Kevin Cox
Crime Prevention Design Advisor
Thames Valley Police Headquarters South
Oxford Road
Kidlington
Oxfordshire
OX5 2NX

REF: 22/02647/F

Location: Unit 6 Oxford Technology Park Technology
Drive Kidlington OX5 1GN

31 October 2022

content: **BUILDING 6A & 6B
 PROPOSED GROUND FLOOR PLAN**
 date: **JUNE 2022**

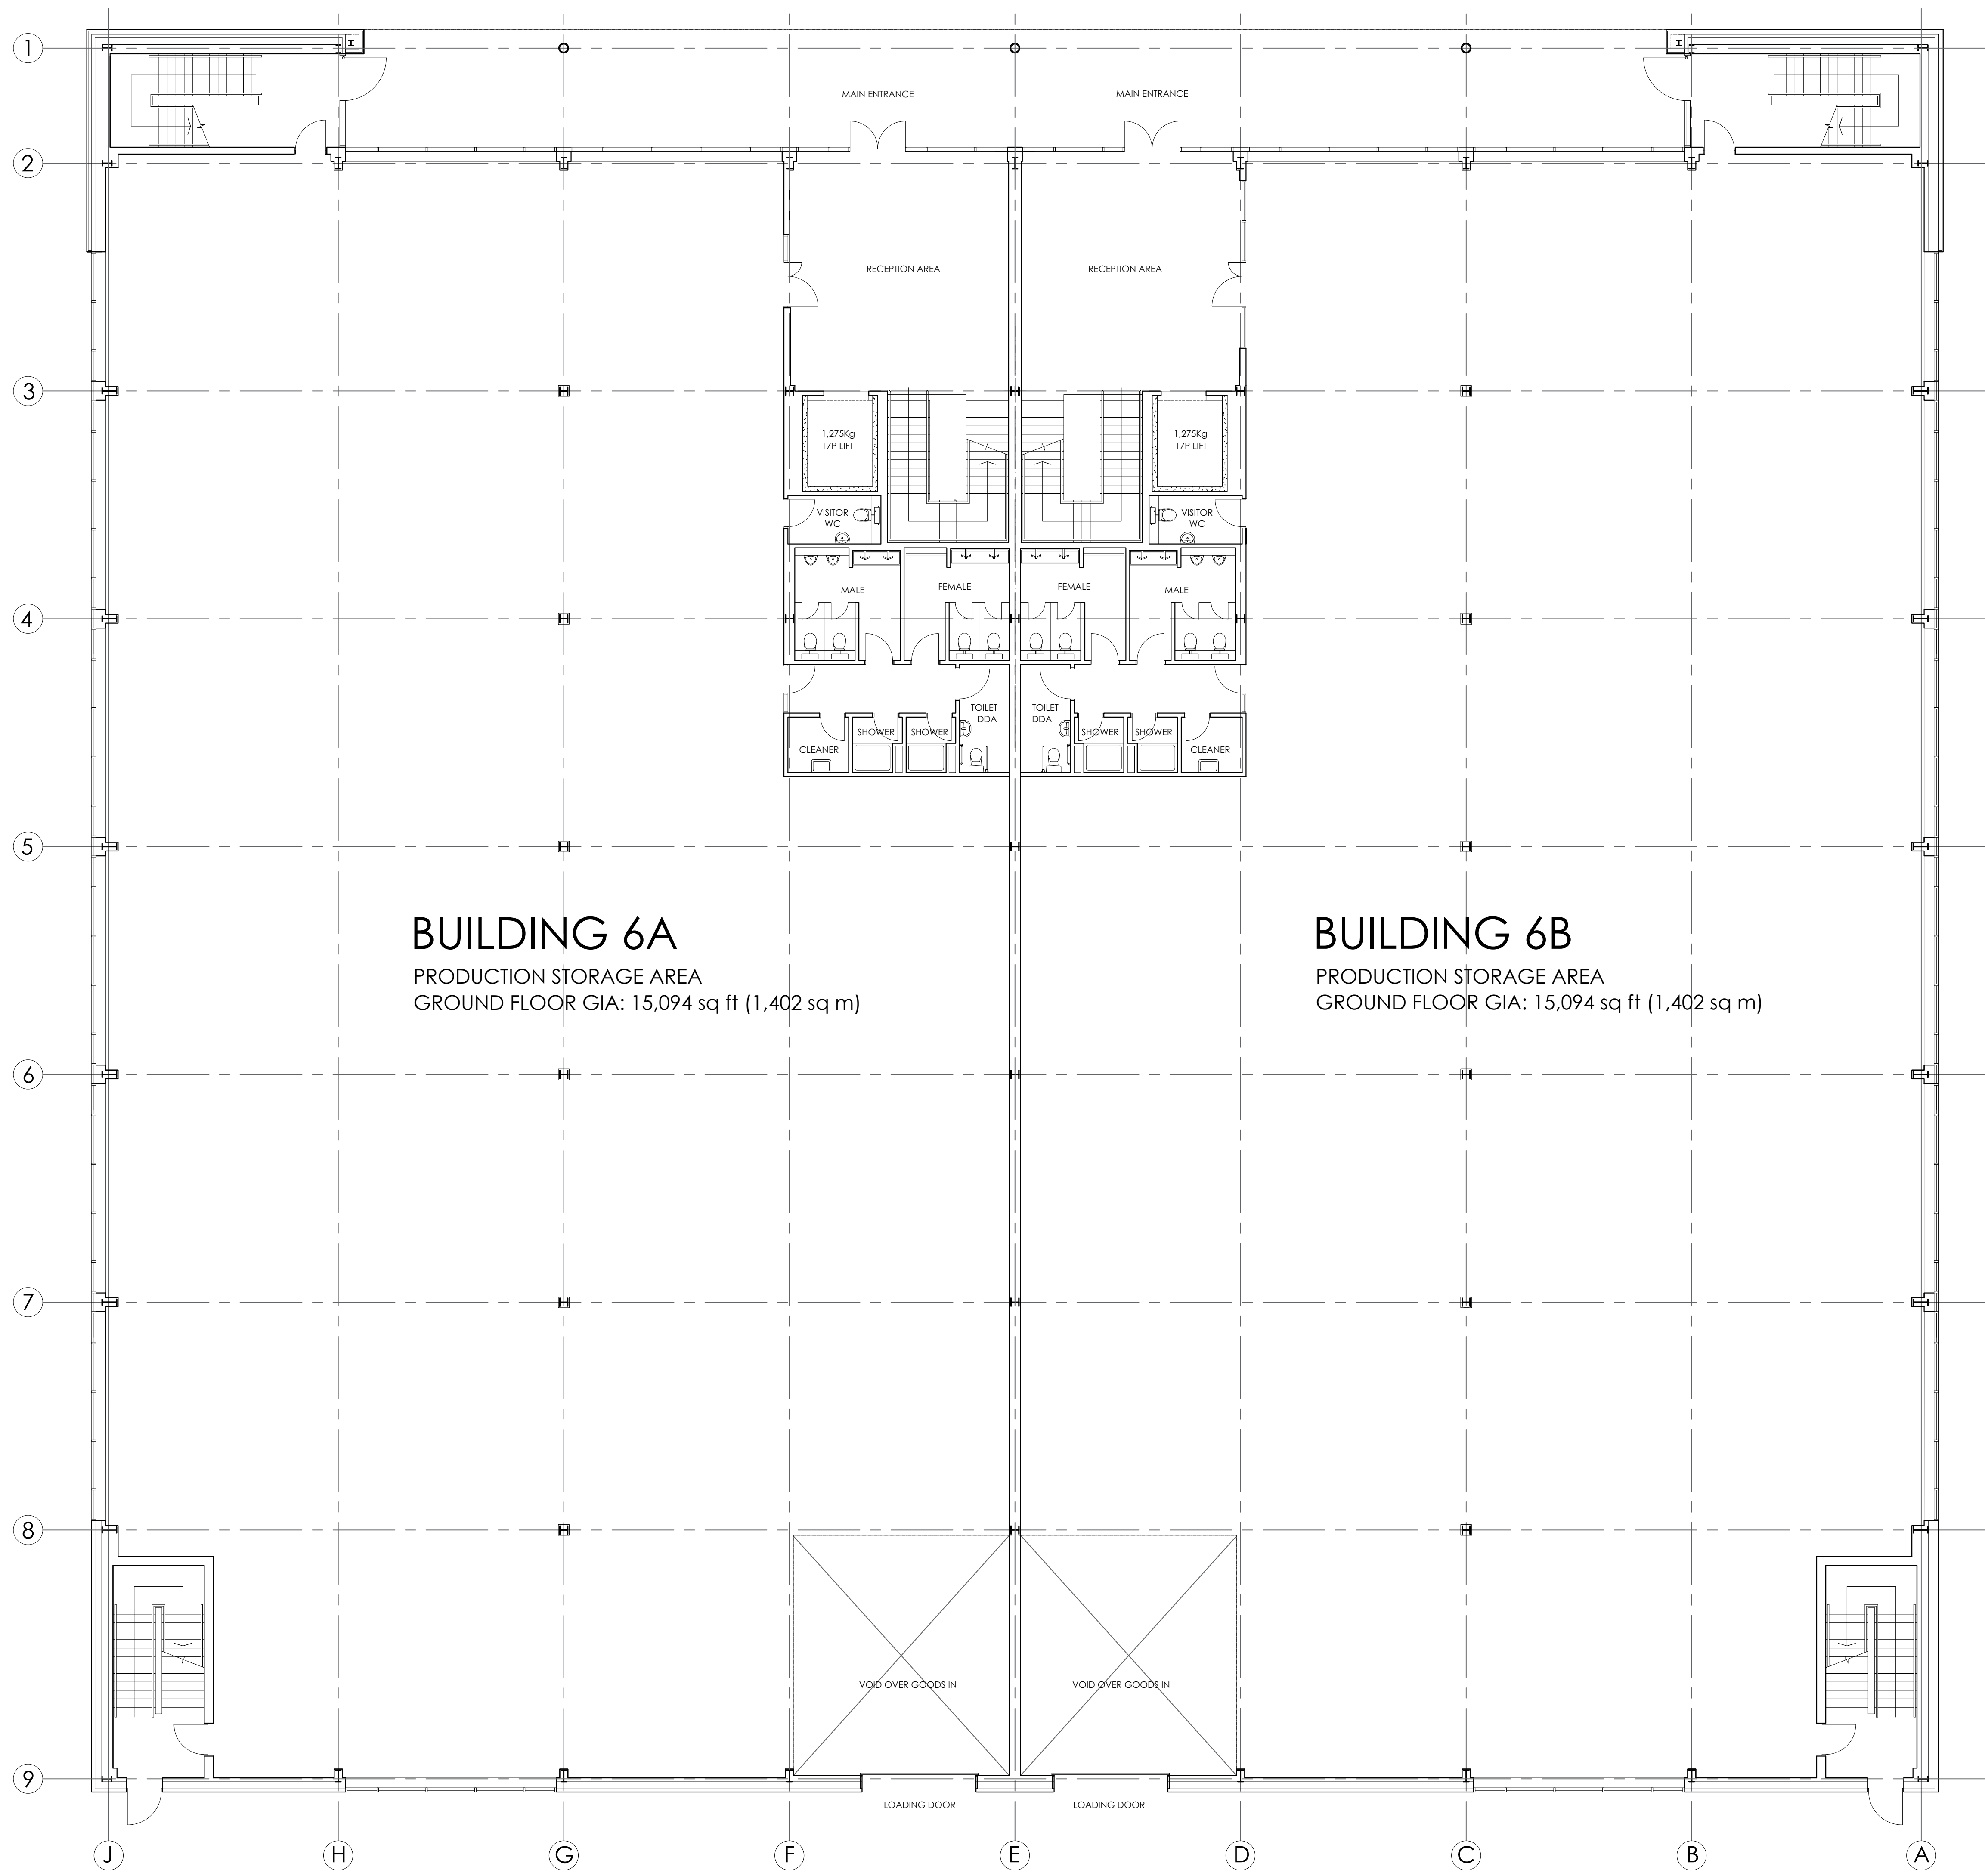
- I recommend a secure line is formed within the reception area of the buildings, with access controlled doors preventing access into the main building area and stair cores. I would recommend an additional door is added to prevent unauthorised access into the main stair core from the main reception area. Lifts should also be behind the secure line or linked to access control systems to prevent unauthorised access.
- In the absence of a known tenant for the building, I ask that all doors, roller shutters, windows (including roof lights), access controls, fences and gates are specified in accordance with at least the minimum standards provided by Secured by Design, Commercial 2015, which can be found here: https://www.securedbydesign.com/images/downloads/SBD_Commercial_2015_V2.pdf

content: BUILDING 6
PROPOSED CYCLE LOCATIONS
date: JUNE 2022

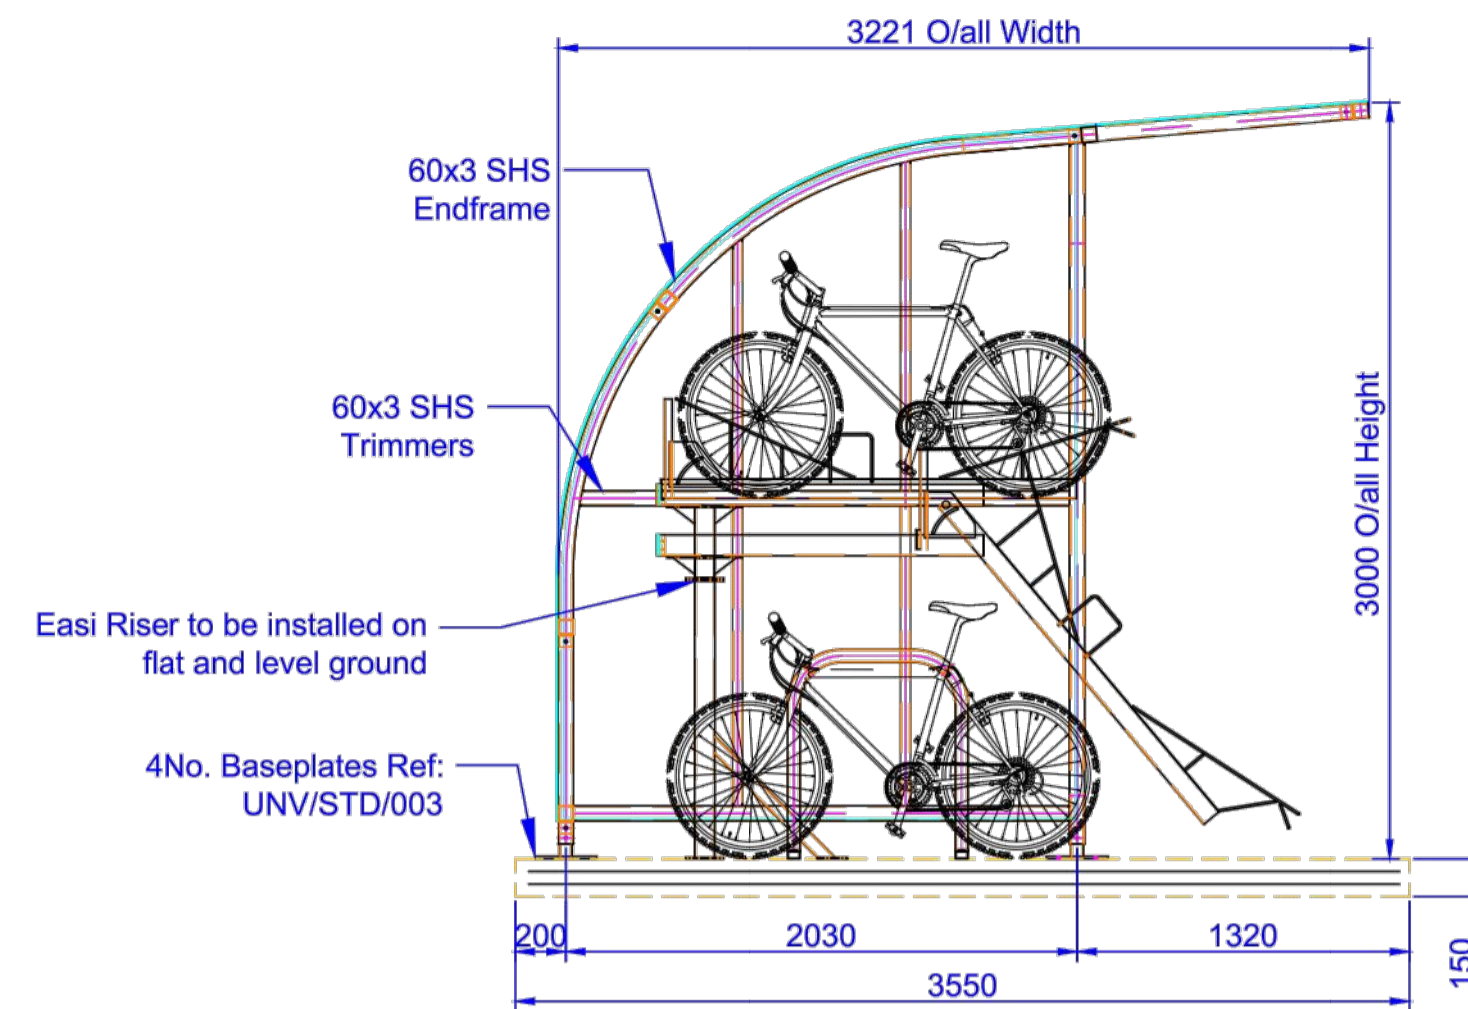
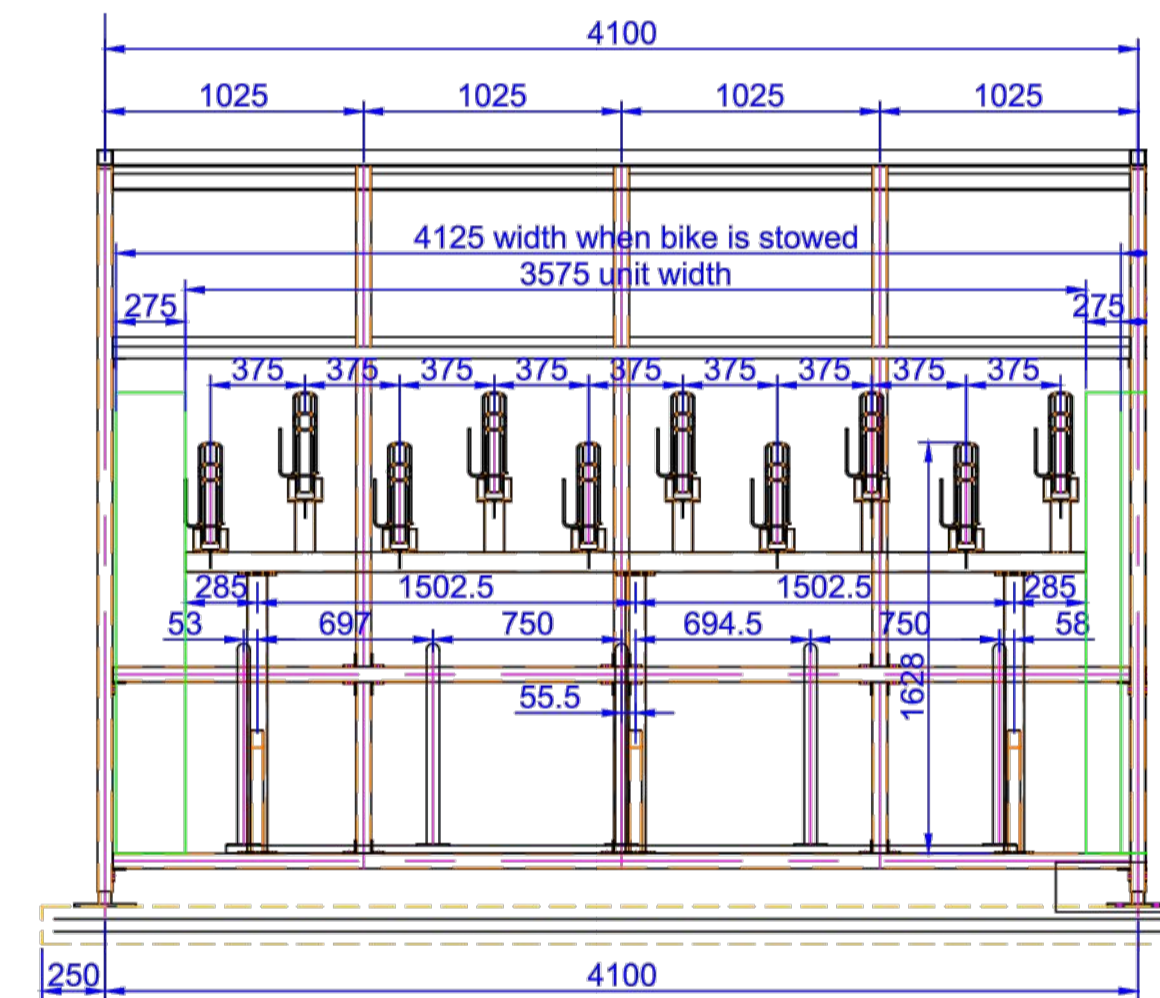
- Cycle parking to the front of the unit is vulnerable, located in an area lacking surveillance due to the blank elevations of the building overlooking. Open cycle parking facilities must be located where they are well overlooked by passive surveillance from the building to reduce opportunities for crime to happen. I would recommend the cycle stores are relocated to within the secure rear compound ideally, where cycles will be protected behind a secure line. Alternatively, they must be located where they are well overlooked by windows from the building to enhance surveillance over them, such as in front of the entrance doors. I also recommend formal surveillance (CCTV) covering the cycle parking should be provided.
